## PRINCE OF WALES DR. DEVELOPMENT

Railway Proximity  
Assessment Review

SYSTRA Canada Reference: 24619-10-GETN-0001\_A

VIA Rail Canada

GRADING PLAN

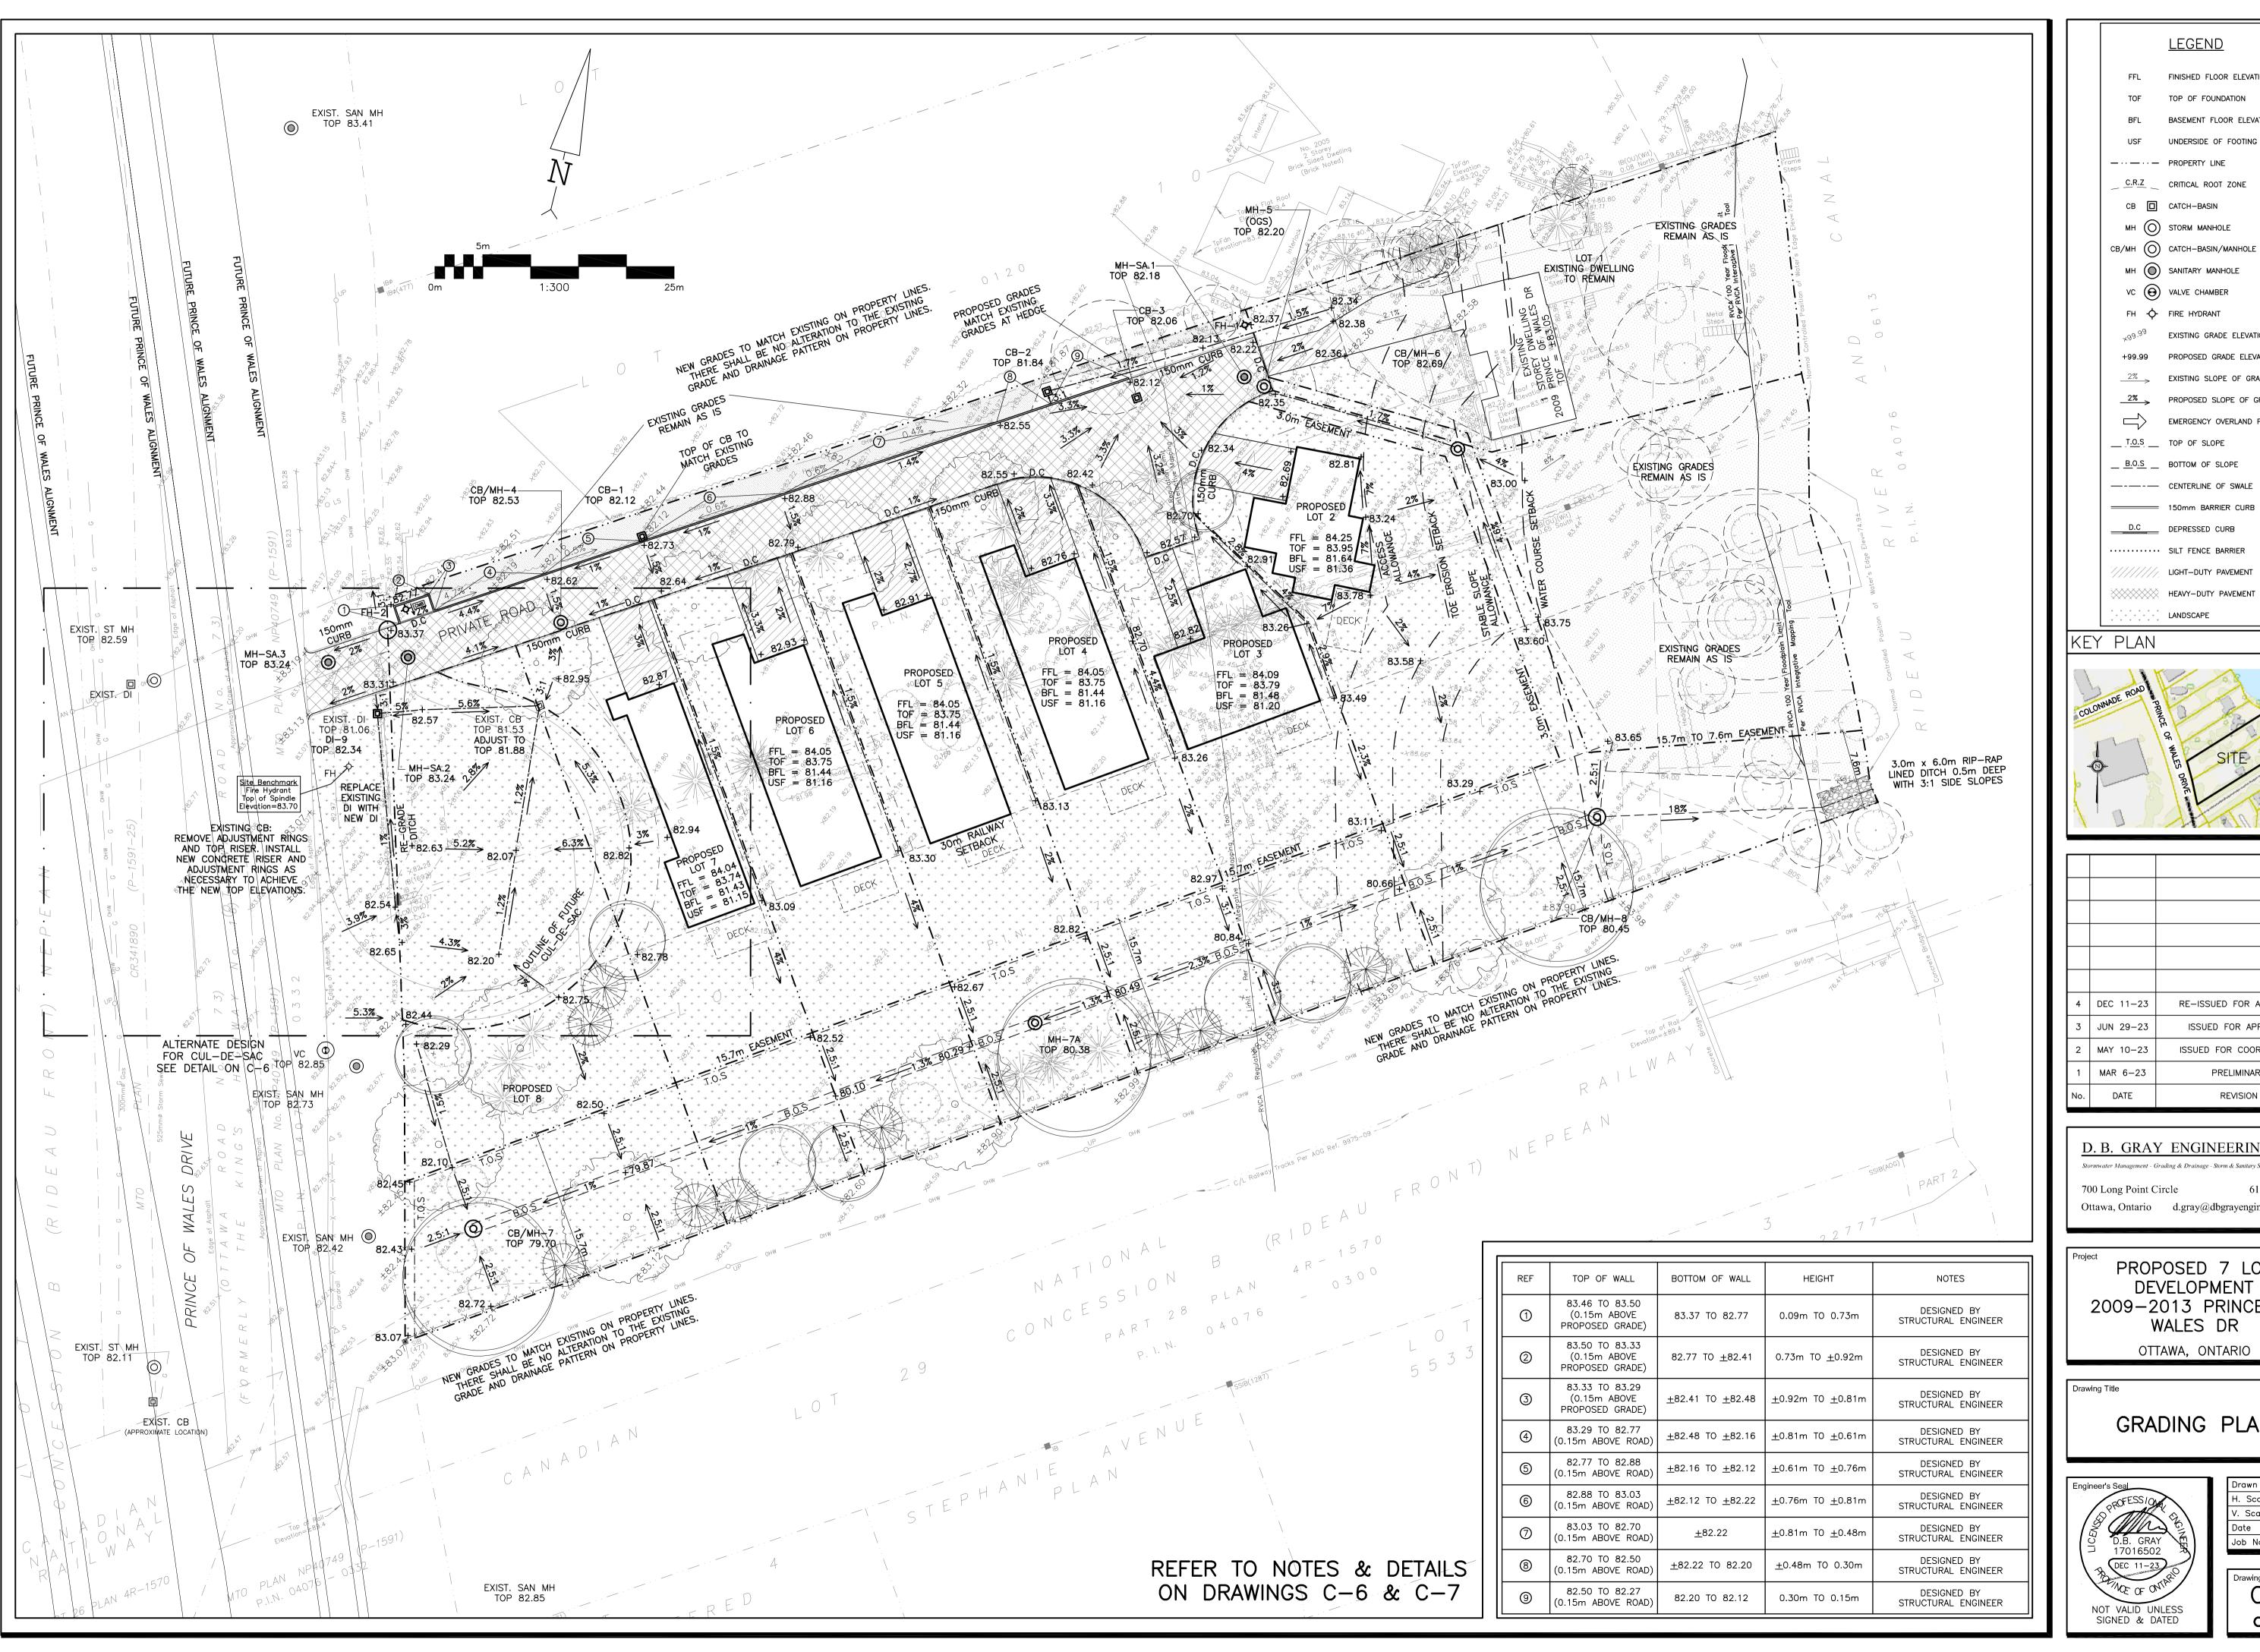
- 1) "Canadian National Railway" shown on drawings C1, C2, C3, C4 for « Proposed 7 Lot Development 2009-2013 Prince of Wales Dr » and the drawing « Topographic Plan of Survey » needs to be changed to "VIA Rail".
